**A12 CHELMSFORD TO A120 WIDENING SCHEME – TR010060
WRITTEN REPRESENTATION – ROYAL LONDON UK REAL ESTATE FUND
13 FEBRUARY 2023**

Subject: **A12 Chelmsford to A120 Widening Scheme – DCO Scheme
Assessment of Impacts at Edmunson Electrical Limited and Royal London UK Real Estate
Fund, Chelmsford**

**Plate 1: Extract from Development Consent Order ('DCO') Plan**

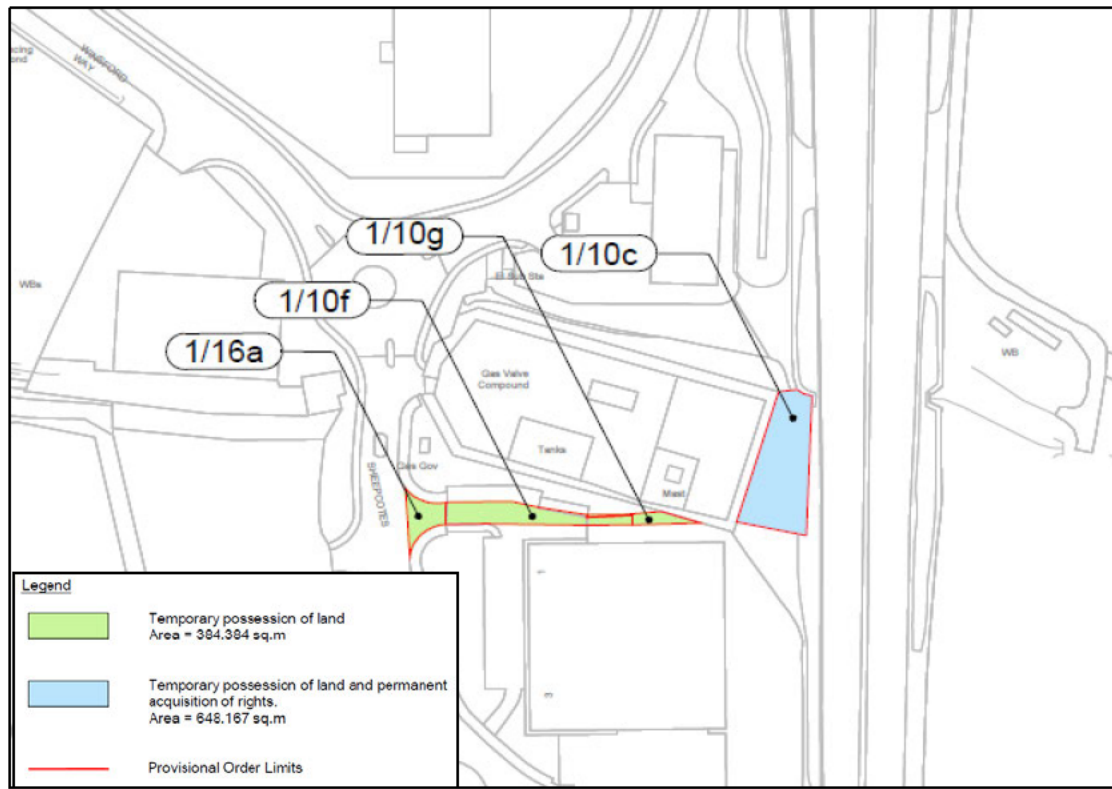
5. The DCO identifies the parcel of land hatched blue, referenced 1/10c, as required to install the proposed diverted gas main works. The parcels of land hatched green referenced 1/16a, 1/10f and 1/10g are identified in the draft DCO as being required for temporary construction access.
6. The 1/10c works as outlined within the draft DCO document states that the works comprise the following:

16. The land parcel referenced 1/10c is located immediately to the north / north east of the EEL site and to the east of the gas compound referred to above.

**Plate 2: EEL in Relation to DCO Route and Sheepcotes (Illustrative)**

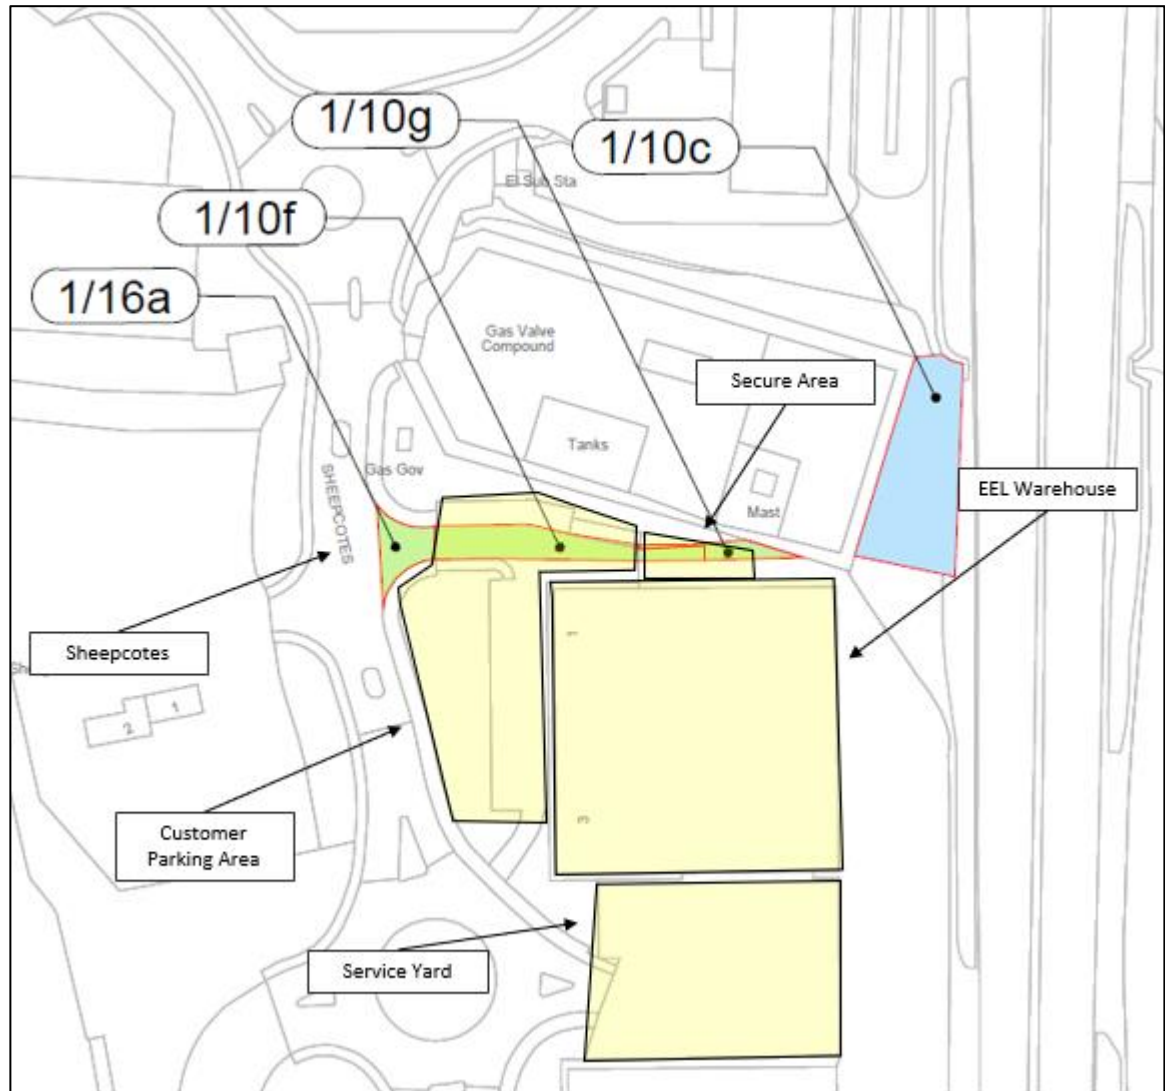
18. The vast majority of LGVs and cars associated with the EEL site access the site via the land covered by the green hatched land parcels while the majority of HGVs access the service yard located along the southern boundary of the EEL unit and accessed via Sheepcotes. According to EEL, the on-site car park is heavily used during normal site operating hours Mondays to Saturdays with very little spare capacity. **Plate 2** below illustrates the different components of the EEL site, in the context of the proposed construction access route.

29. However, no vehicle swept path analysis has been provided for the access route through the EEL site or of the proposed compound to the rear of the gas compound to demonstrate that vehicles can be driven through the EEL site in forward gear.

30. Furthermore, the Applicant has not demonstrated via the results of swept path analysis that the width of the access route is adequate for the vehicles that are anticipated.

31. The application does not include swept path analysis demonstrating that construction vehicles would not need to wait to pass another construction vehicle on the access route through the EEL site.

37. The proposed access route passes through the EEL site but ends at the boundary of the gas compound (as shown on Plate 2 above). The route through the EEL site does not connect with land parcel 1/10c. There are no details provided as to how access through the gas compound is to be achieved and it is noted that Cadent themselves object to the proposals. Such details will be required in order for EEL and RL to consider the effects of the proposals on the operation of the EEL site in further detail.

"The order limits have been designed not to encroach on any of the parking bays within the limits of land plot 1/10f. This is solely for access only, no construction vehicles related to the proposed scheme would park or obstruct this area. EEL and its customers will be able to continue to use the access throughout the works and the Applicant will endeavour to minimise any disruption".

**Plate 4: Order Limits (Extracted from Appendix B of the OCTMP)**

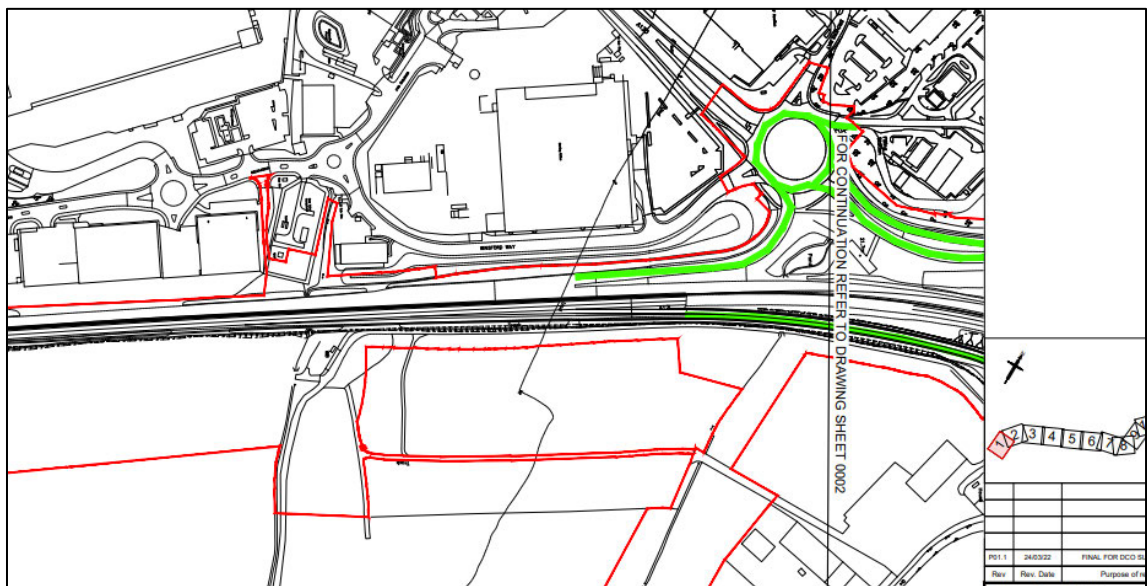
36. The Order Limits includes land on the north side of the gas compound but the application does not include clear or detailed reasons why this alternative route to the gas works site has not been considered appropriate / deliverable.
